SW/01/n1982

RE: Planning Application under Section 73 of the Town and Country Planning Act (1990) to vary condition 2 pursuant to Planning Permission ref: 2023/0195 for Residential development of 95no. dwellings (Amended Plans) at Land North of Barnburgh Lane, Goldthorpe.

This Section 73 application seeks to make amendments to the Planning Layout associated to condition 2, and subsequently update any other plans associated with condition 2 to accord with the new layout.

Project: GL2047 01E

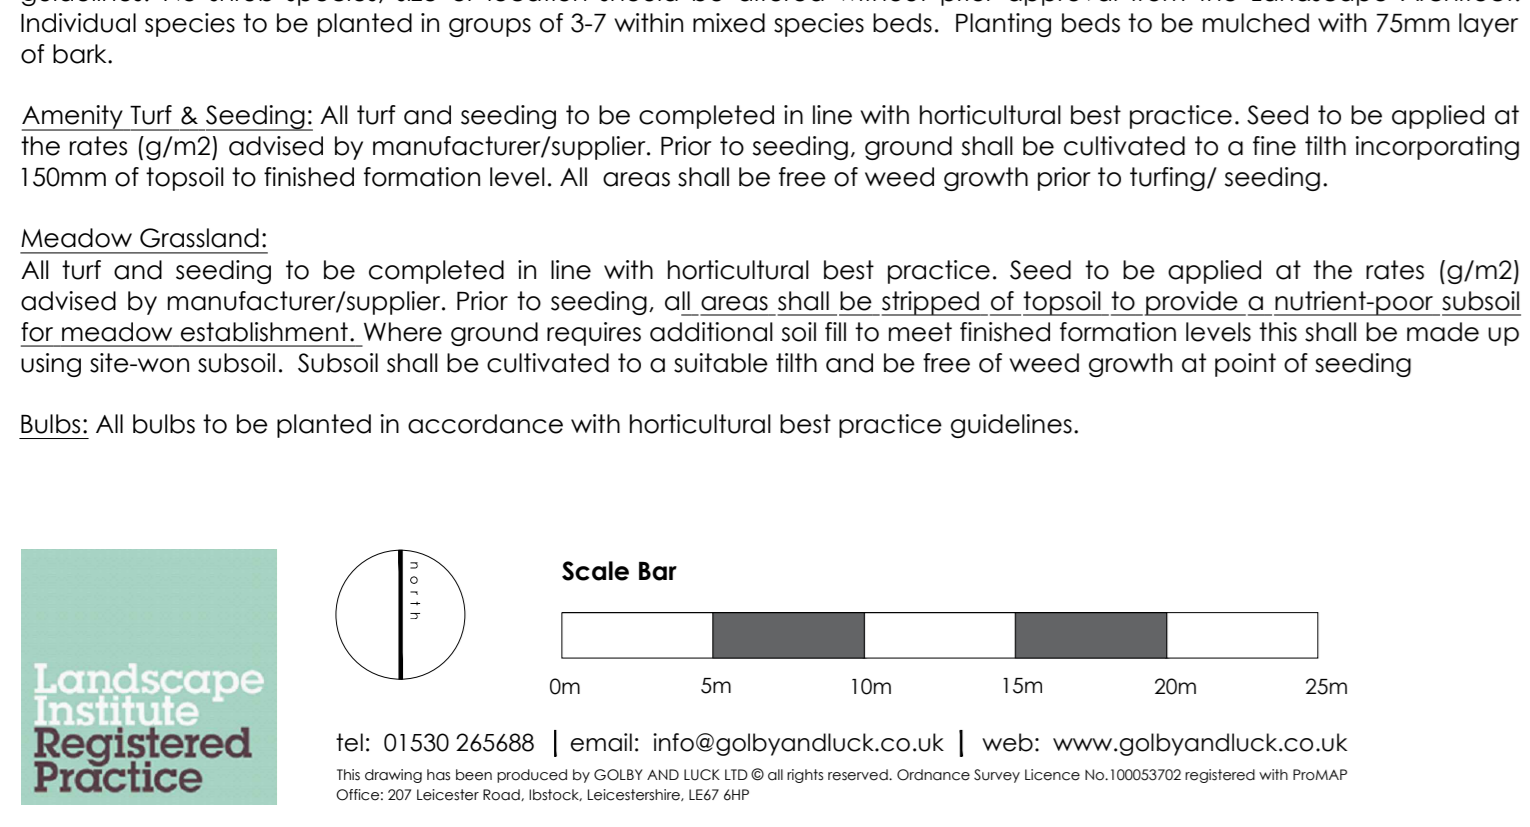
- *Planning Layout – 008 REV L*
- *Soft Landscape Proposals GL204701F*
- *Soft Landscape Proposals GL204702F*
- *Boundary Treatment Plan 700 Rev F*
- *Garden Areas Plan 101 Rev D*

Project:
Barnburgh Lane,
Goldthorpe
Drawing Title:
Boundary Treatments Plan

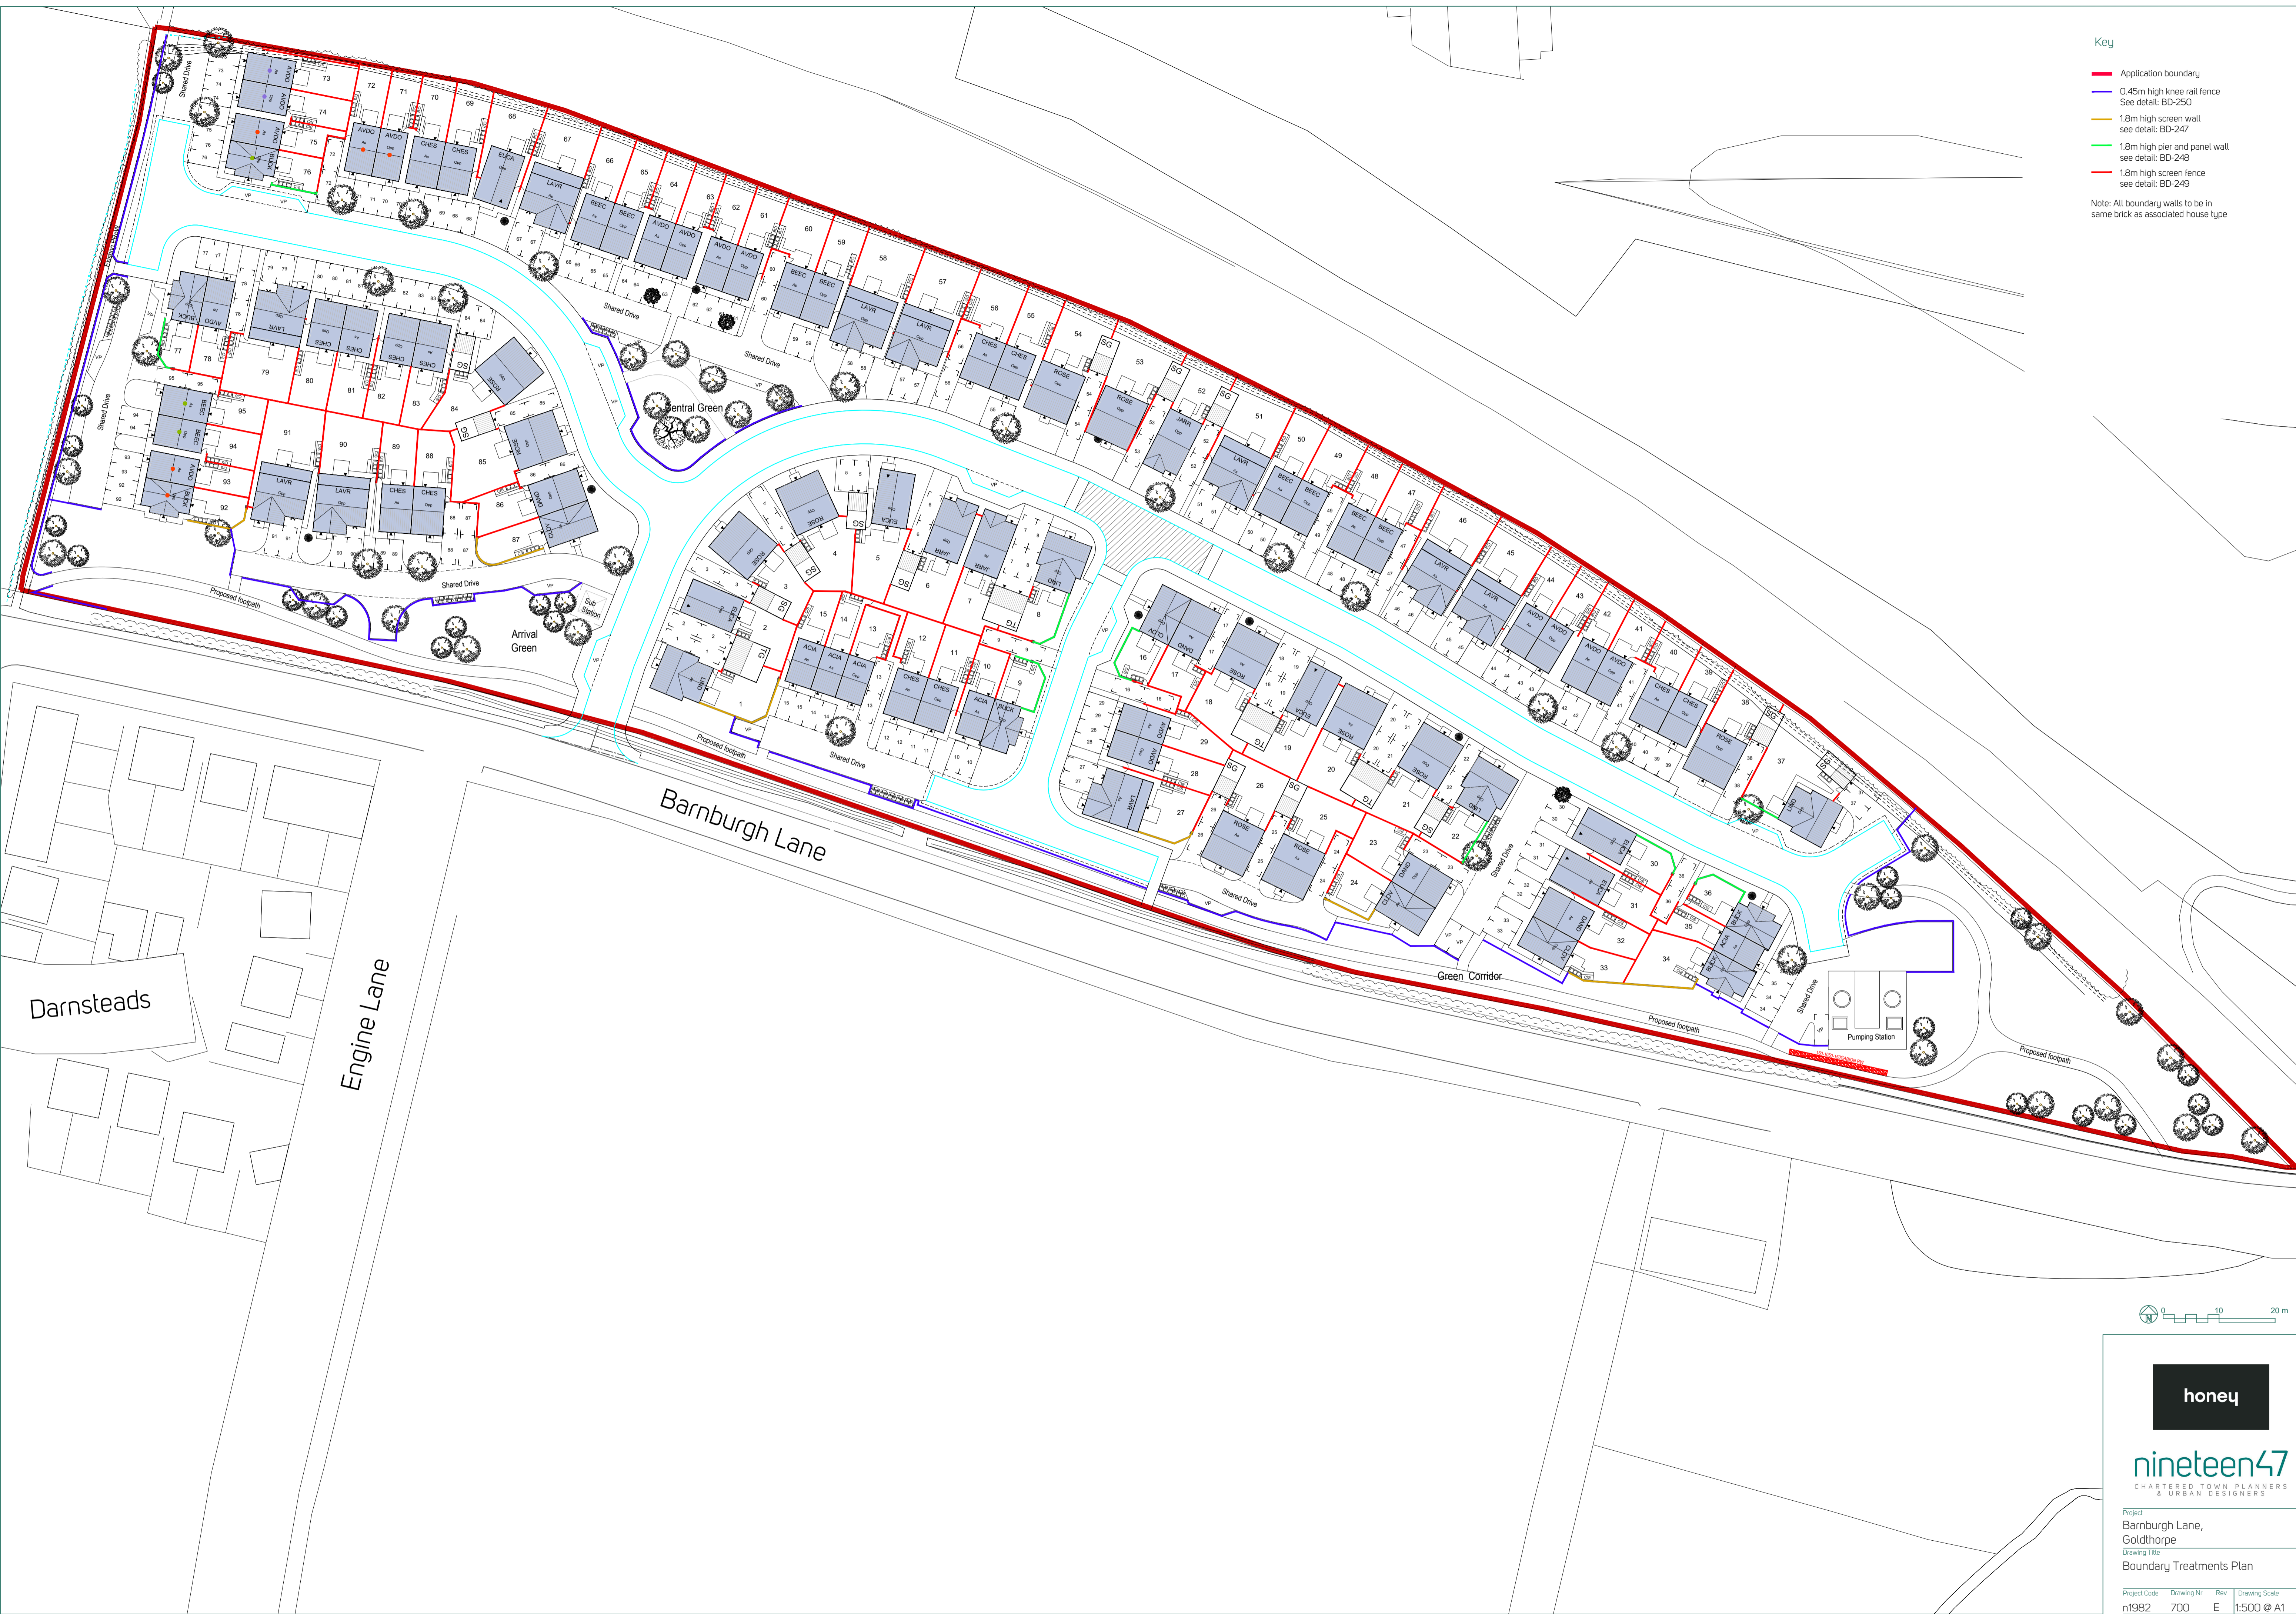
In addition, a footpath and gabion wall amendment has been included in the updated layout to facilitate level changes for the pump station.
